A12 Chelmsford to A120 Widening

Response to DfT
Consultation Letter dated
27 October 2023

9 November 2023

Drawing title
**TRAFFIC REGULATION MEASURES
SPEED LIMITS
SHEET 14 OF 21**

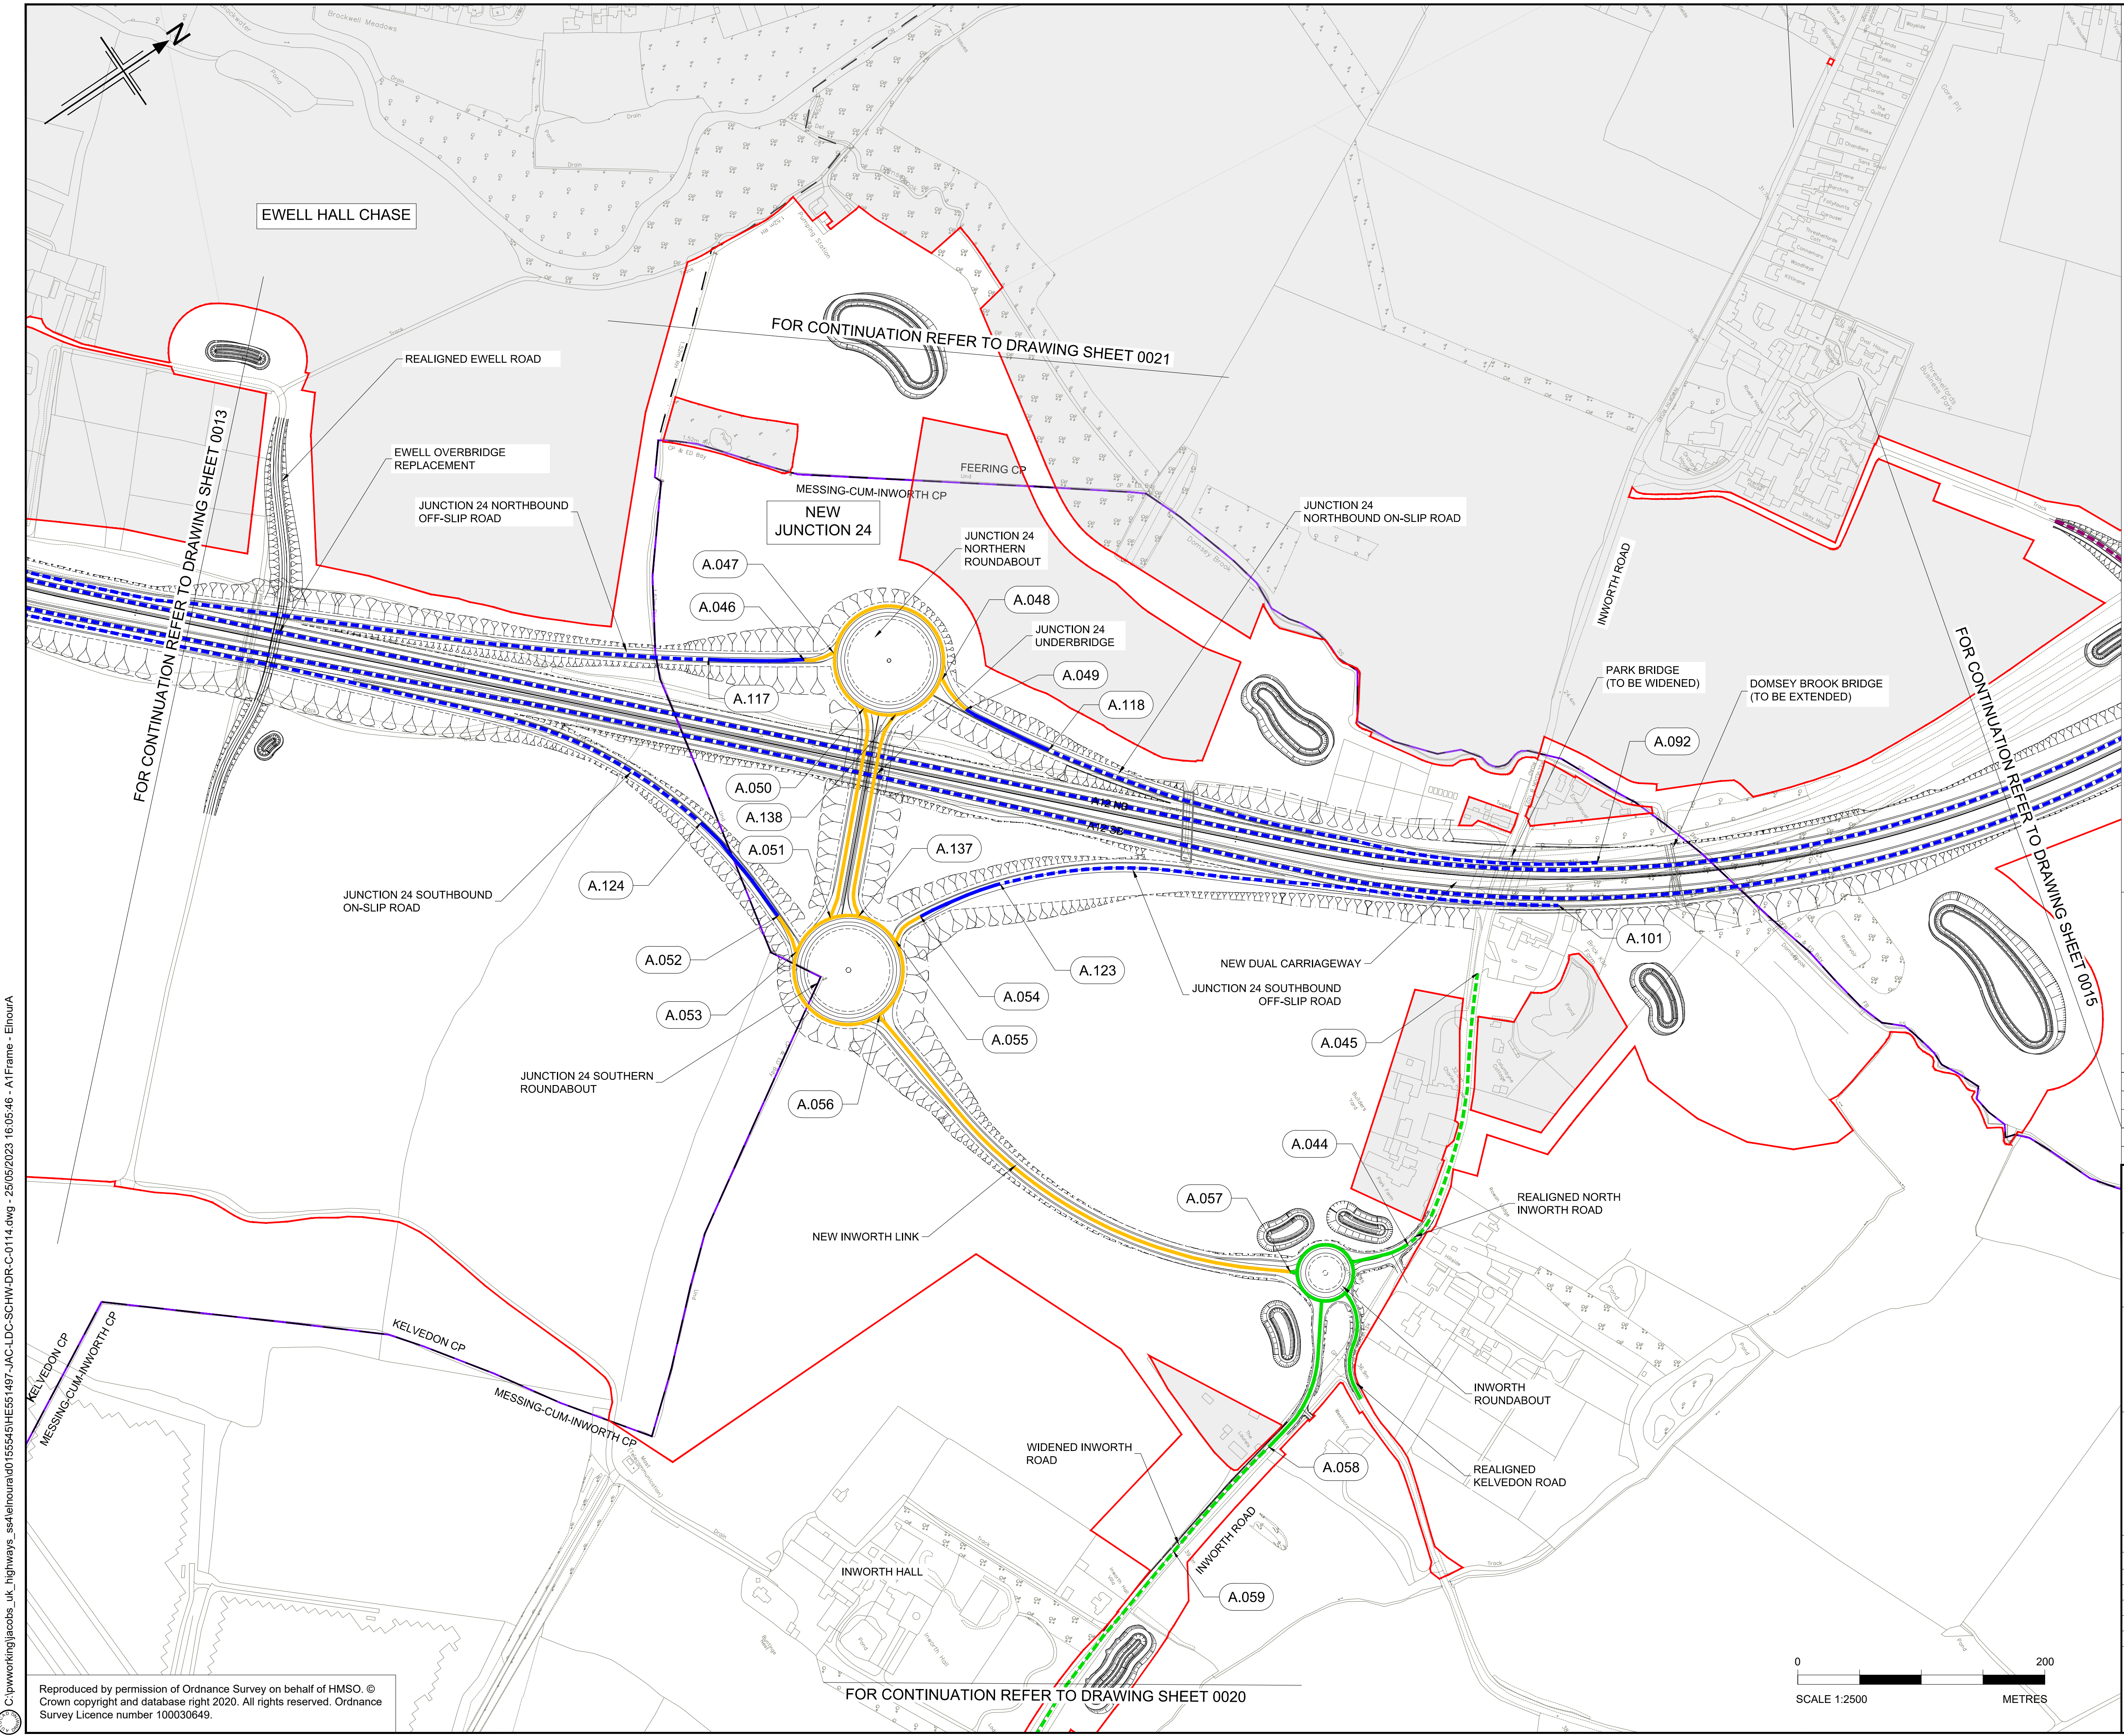
The Applicant has explained that, in some locations, the existing or proposed vertical and horizontal alignment and/or cross-sections of the road will affect the characteristics of the road (which is not comprehensible from the General Arrangement drawings we have seen hitherto) in a way which encourages speed limit compliance. However, detailed alignment information demonstrating this has not yet been shared with the Council. Furthermore, the Applicant has agreed to provide the rationale for their proposed speed limits at the locations where the Applicant and Council remain in disagreement, and to develop potential mitigations to encourage speed limit compliance should this be deemed necessary. We are still awaiting this information.

As it stands, the Council maintains that the speed limits have been set too low for the character of road on five key sections of highway (totalling around eight kilometres in length):

- The de-trunked A12 from Witham to Rivenhall End (East)
- Braxted Road (south of the junction Henry Dixon Road, Rivenhall End)
- The new B1024 Link Road between Rivenhall End and Kelvedon
- The new Essex County Fire and Rescue Service Access Road
- The de-trunked A12 between Feering and Marks Tey
